Item No. **Report of the Head of Planning, Transportation and Regeneration**

Address 18 LINKSWAY NORTHWOOD

Development: Erection of a detached 7 bed dwelling with basement and habitable roof space to include 4 rear dormers including demolition of existing dwelling, replacement new wrought iron gates and piers and removal of the front boundary brick walls

LBH Ref Nos: **2695/APP/2021/466**

rev:	date:	description:
scale:	1 : 100	A1 date: 12 / 01 / 2021
drawing no:	1366 / P / 3	drawn: FJ
drawing:	PLANNING PROPOSALS, FIRST & ROOF FLOOR PLANS & REAR ELEVATION	
project:	LAND AT 18 LINKSWAY, NORTHWOOD, MIDDLESEX, HA6 2XB	
client:	DDA

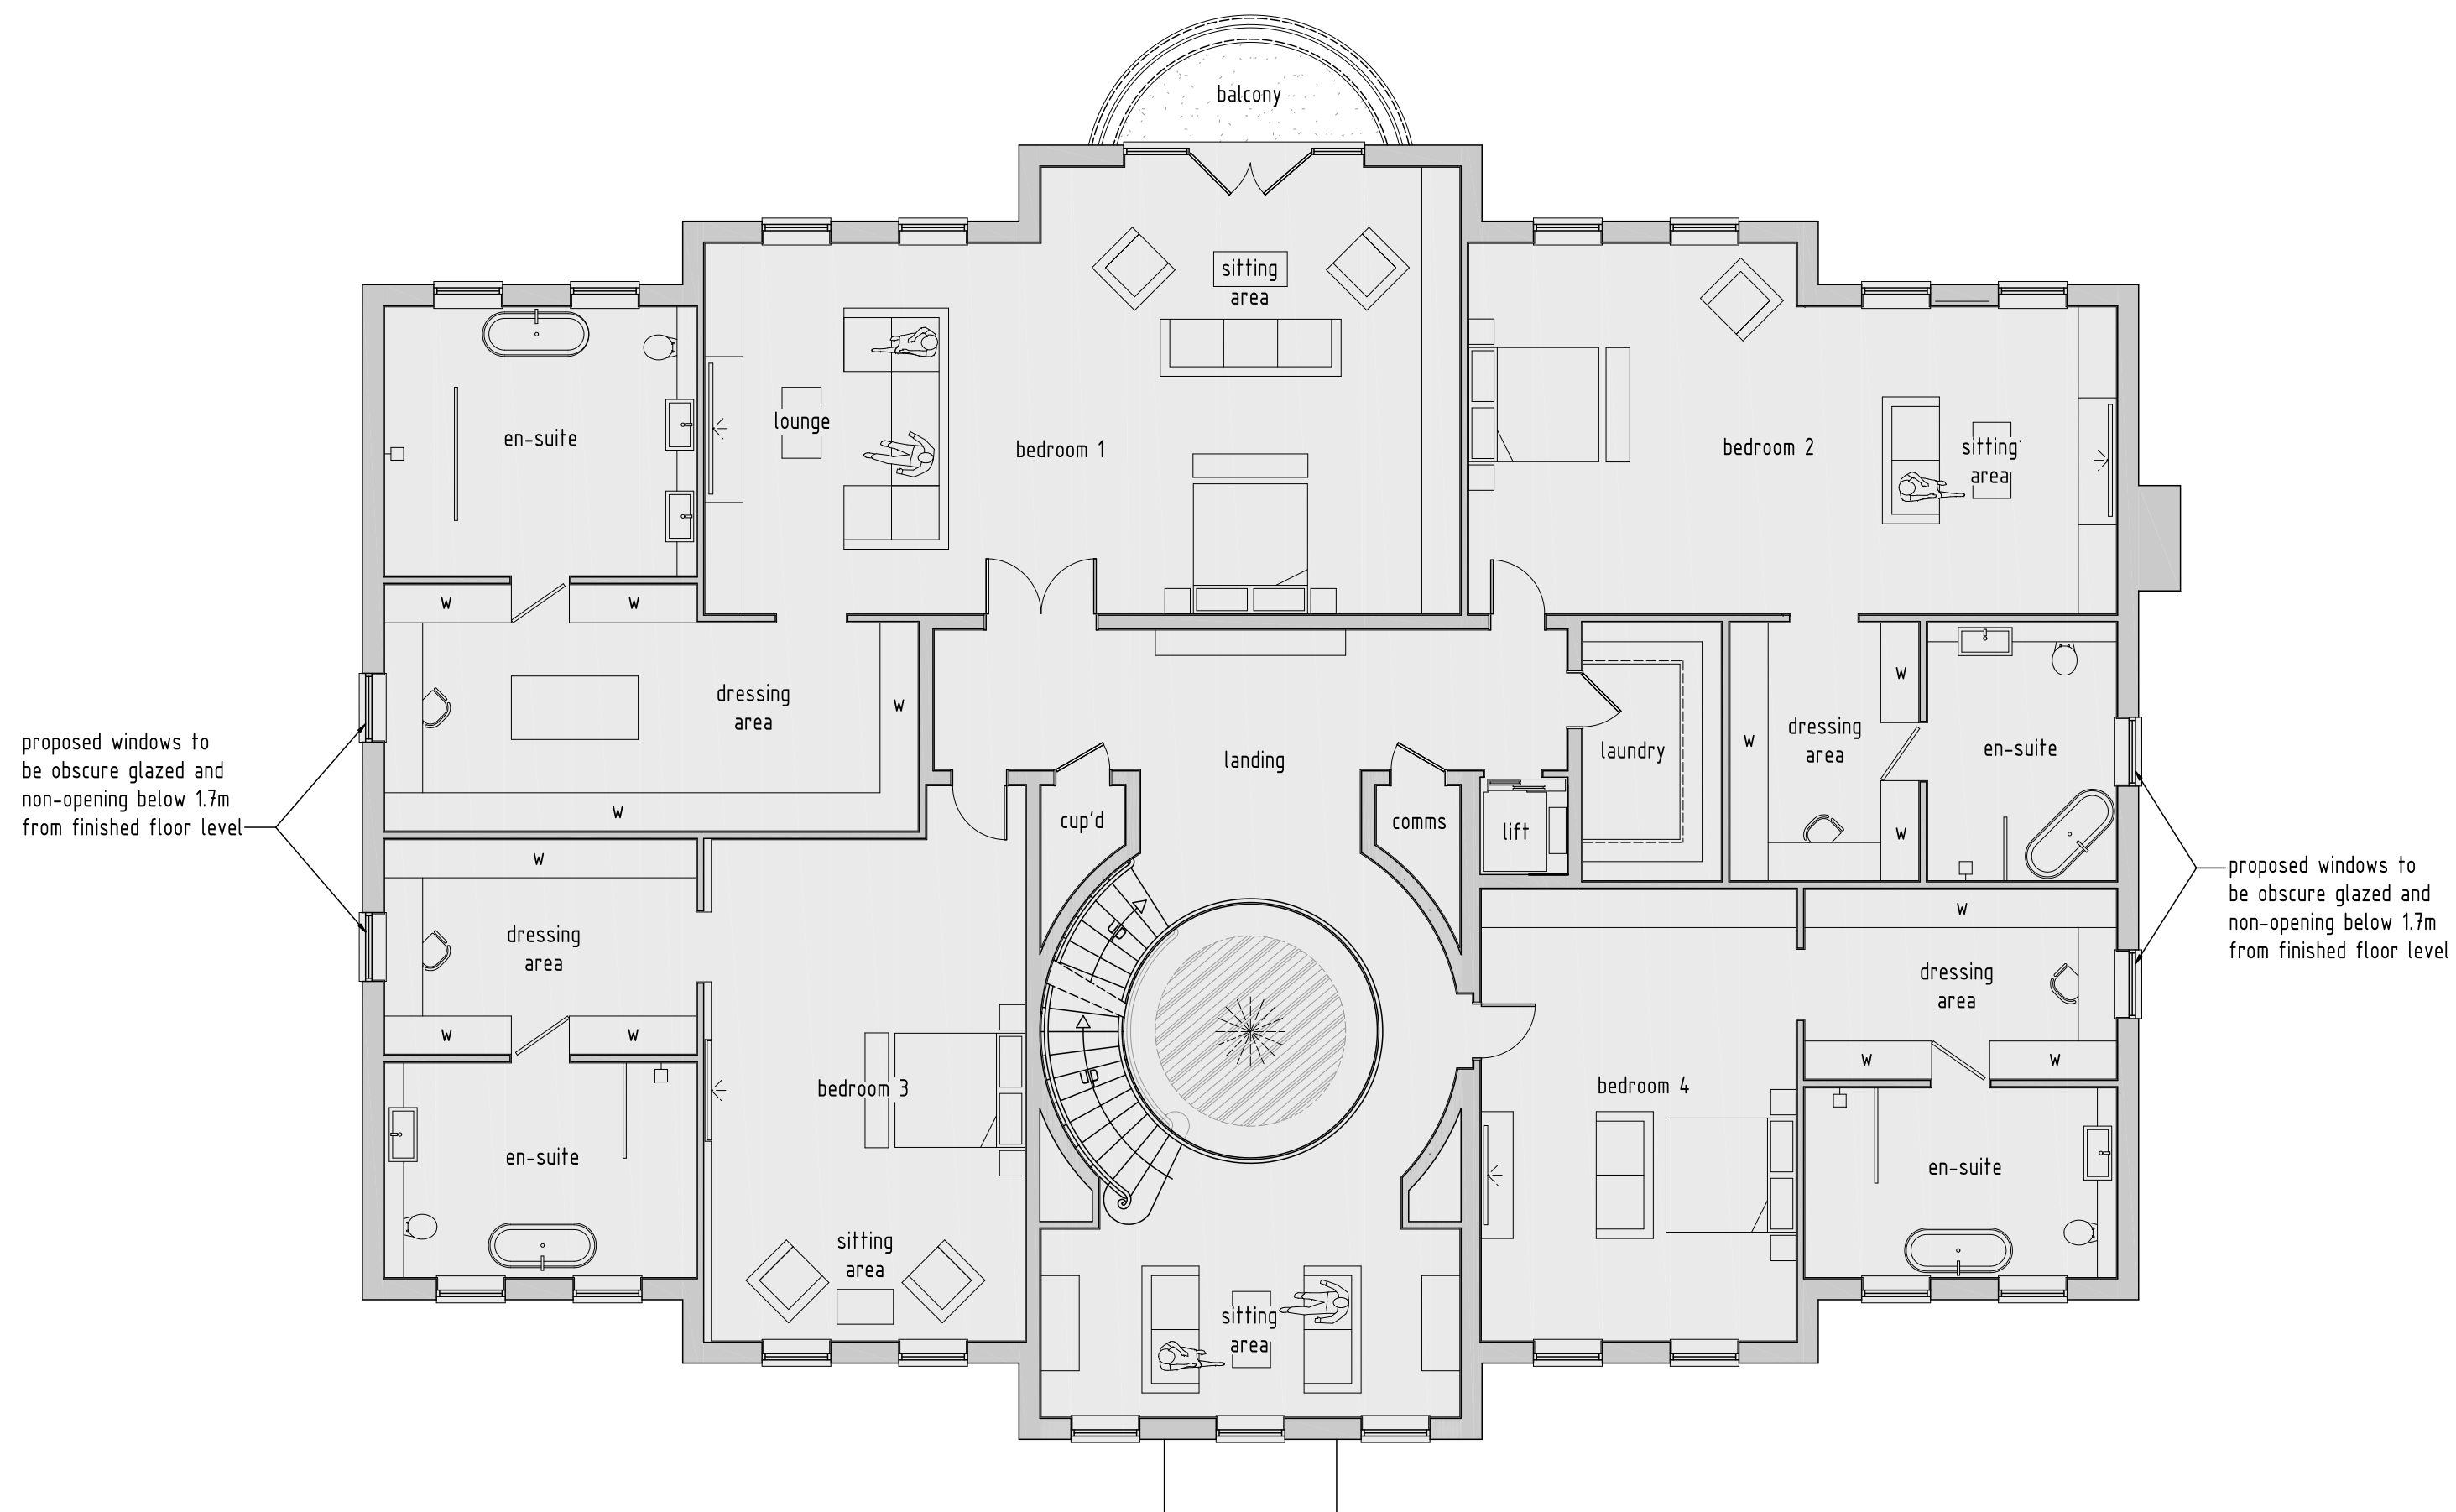
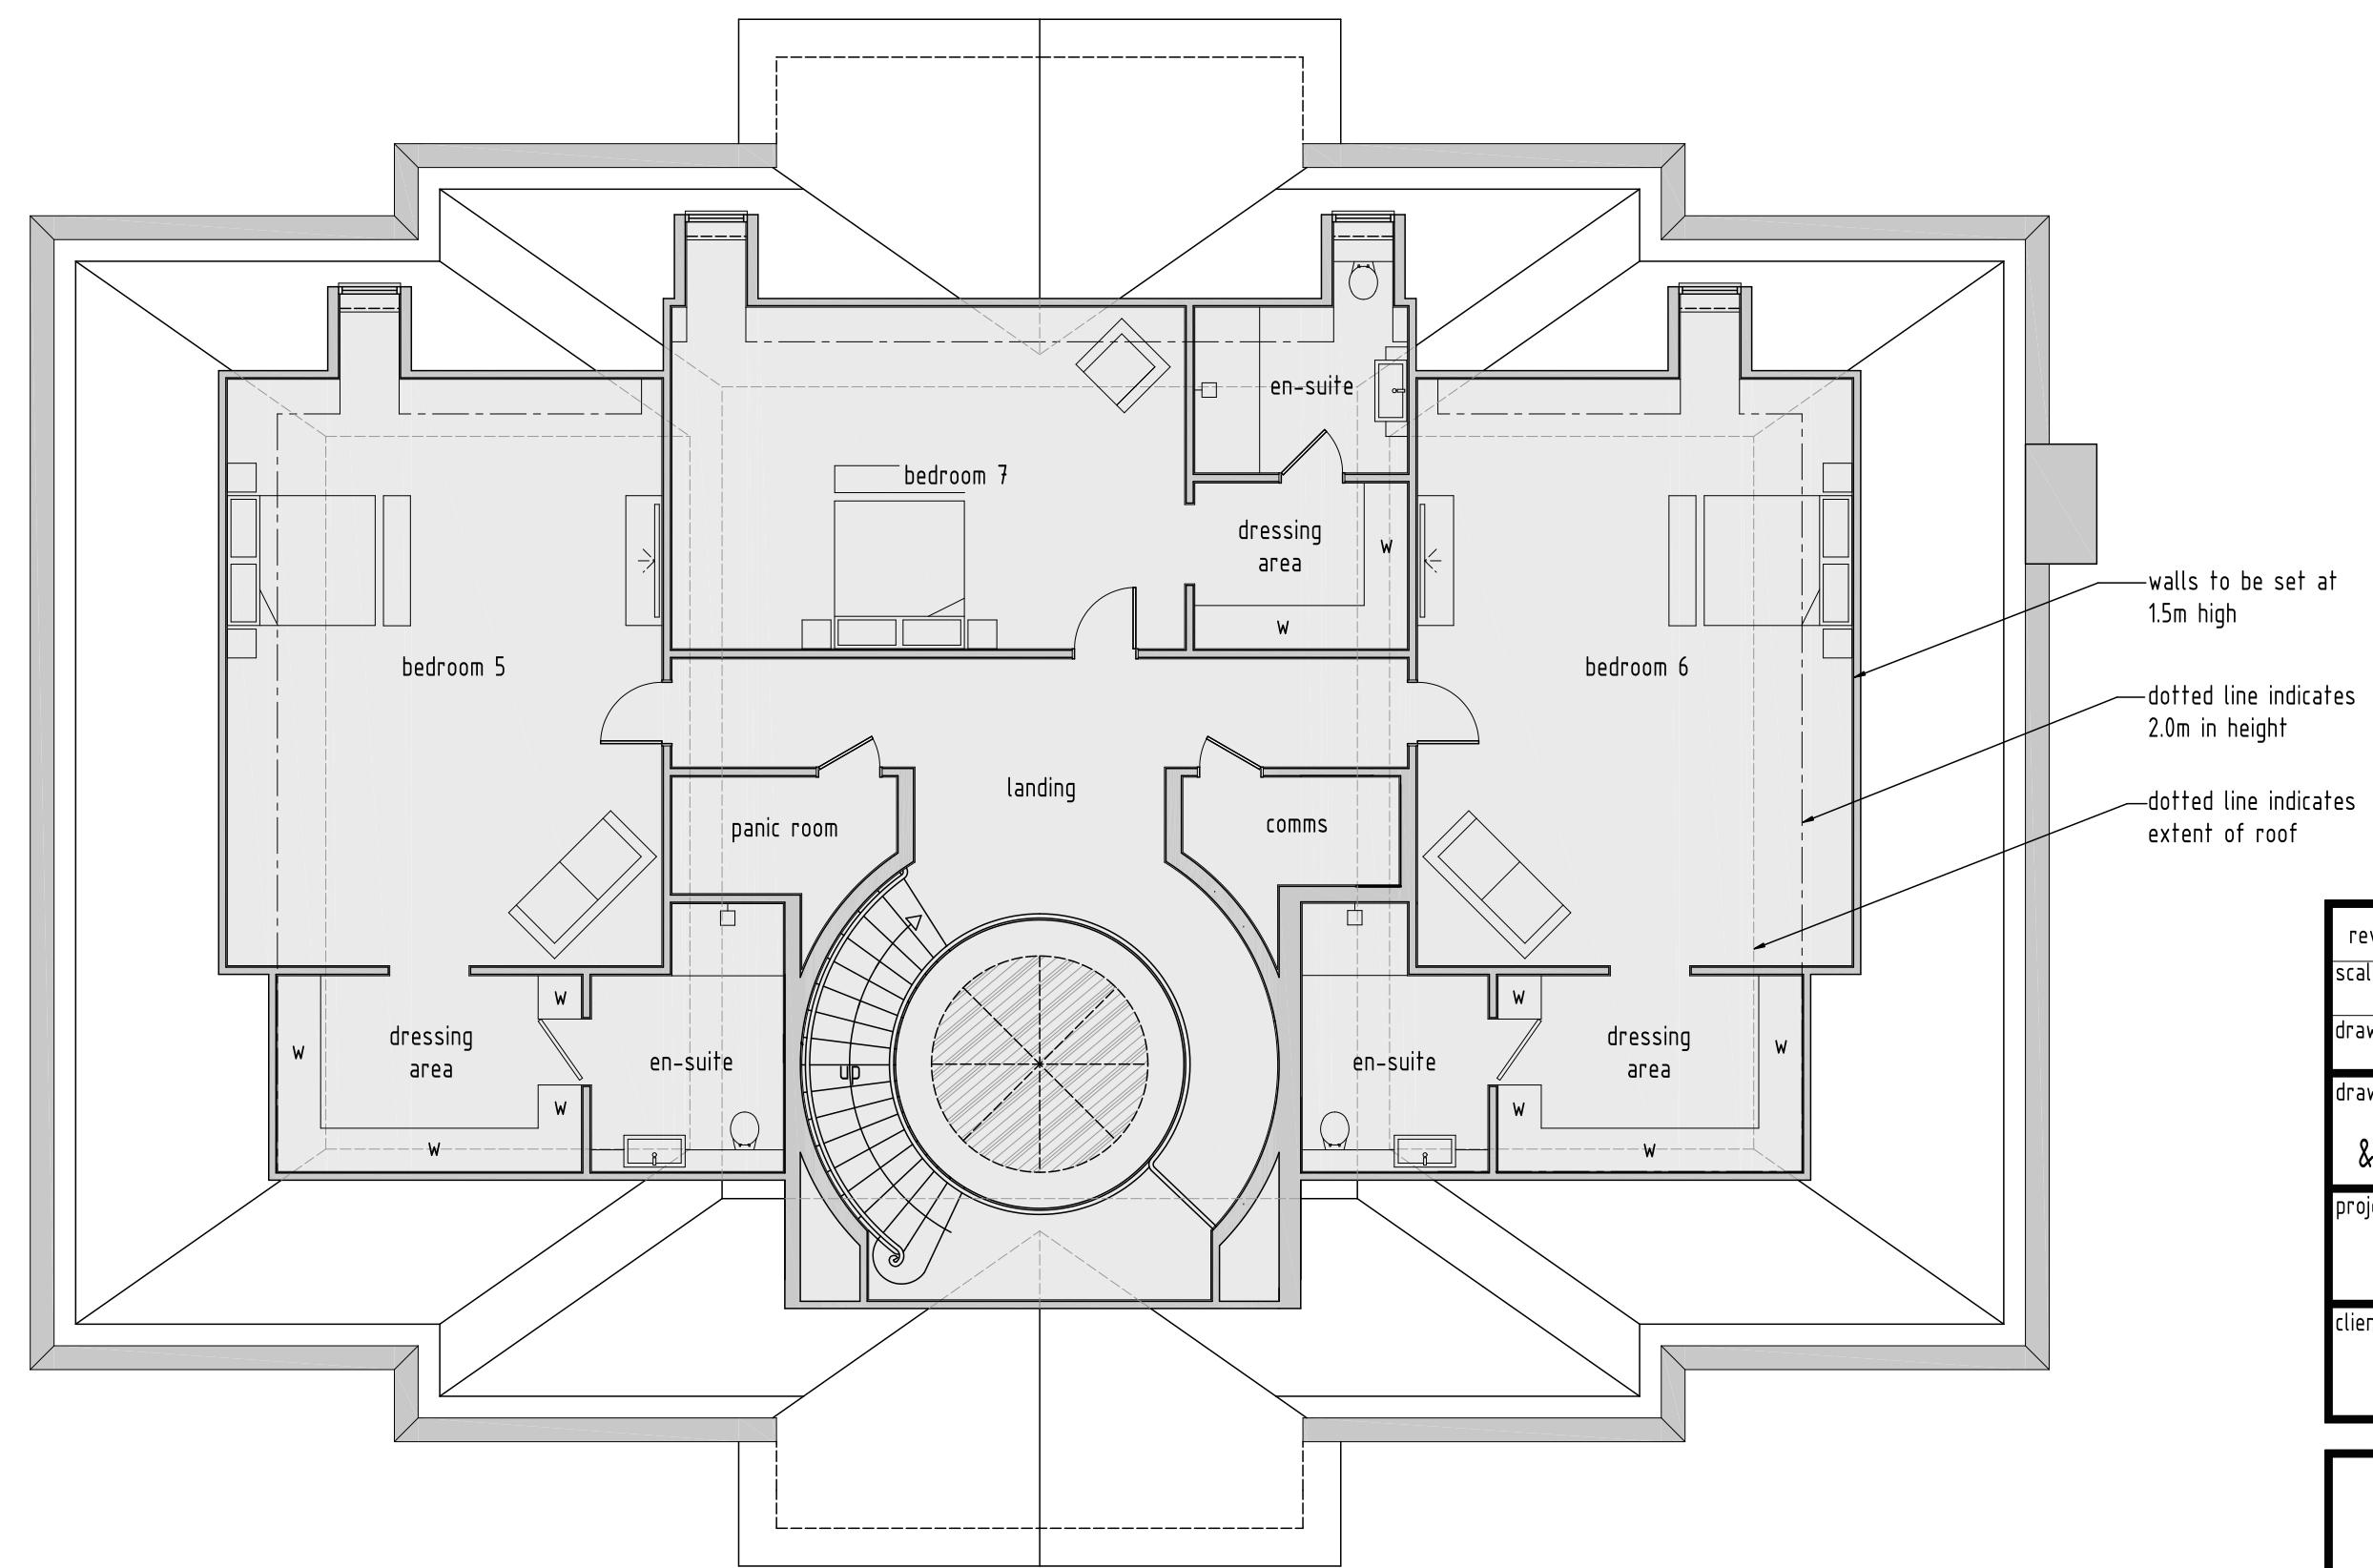
The large pediment at roof level would unacceptably draw undue attention to itself along the street scene.

The proposed development would extend across the great width of the site with small gaps retained along the side boundaries. Whilst the footprint may be slightly smaller than the existing building, the scale and bulk of the built form is vast and further accentuated by the design and detailing of the building. The proposed columns elongate the height of the building and the large crown roof exacerbates the bulk of the development.

The inclusion of the large areas of crown roof would continue a detrimental precedent within the ASLC. Crown roofs are not a traditional or original characteristic feature of the ASLC. New developments should be able to achieve fully hipped roof forms.
